**From:** Jeff Watson  
**Sent:** Tuesday, April 30, 2013 2:47 PM  
**To:** 'harleyp@alphasub.com'  
**Cc:** 'terryo@alphasub.com'  
**Subject:** LP-07-00060 Sunset Farms

LP-07-00060 Sunset Farms Long Plat in Kittitas County

Your Job No. 207203

**SITE PLAN  
OF  
SUNSET FARMS**

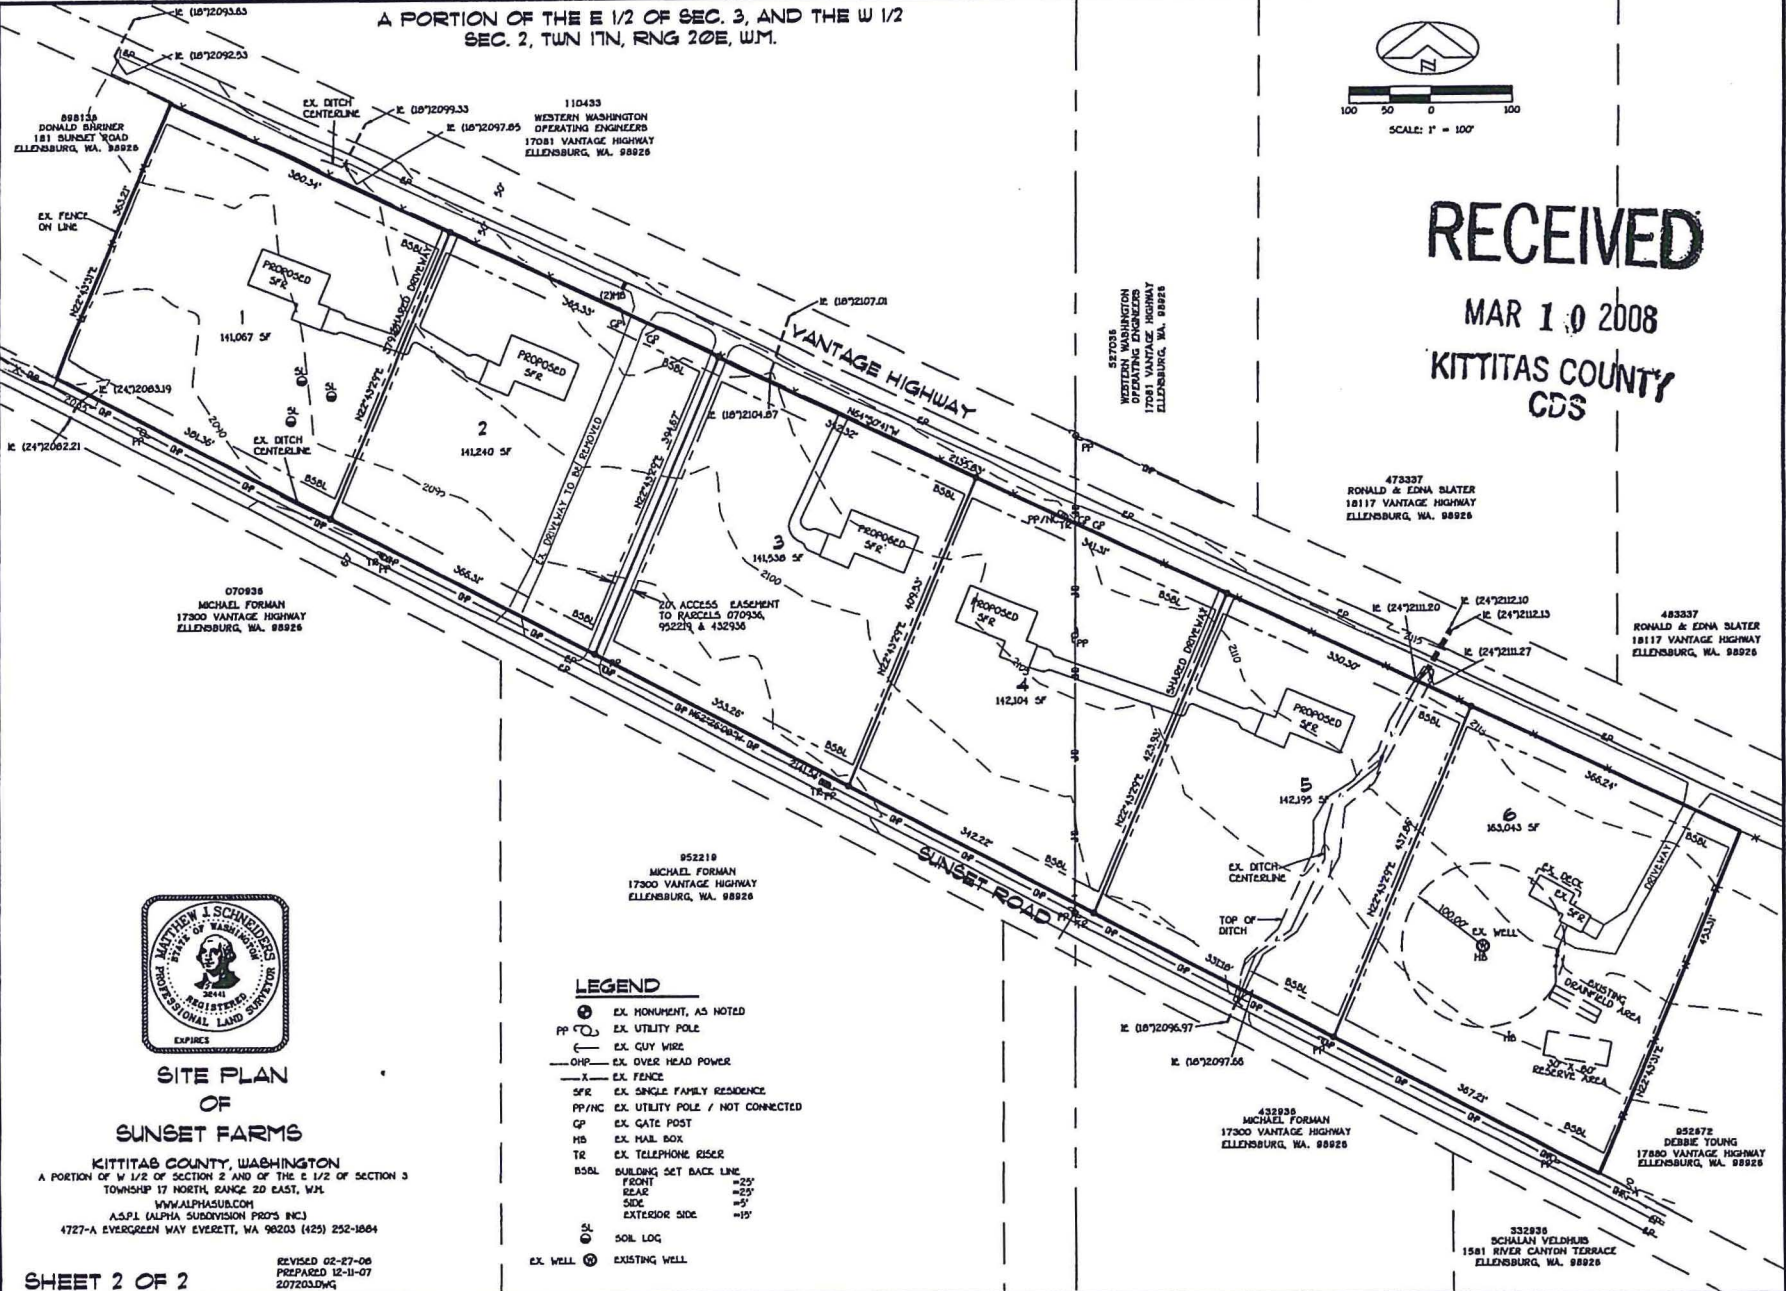
[Kittitas County Code Chapter 16.20](#) outlines the requirements for final plats; The mylars you sent to our office regarding the above plat do not depict the well location and 100 ft radius as required by 16.20.040(16). We will also need a title report to verify dedications as required by 16.20.030 (we have computer closures here; I trust they are still valid). Please feel free to contact me should you have any questions.
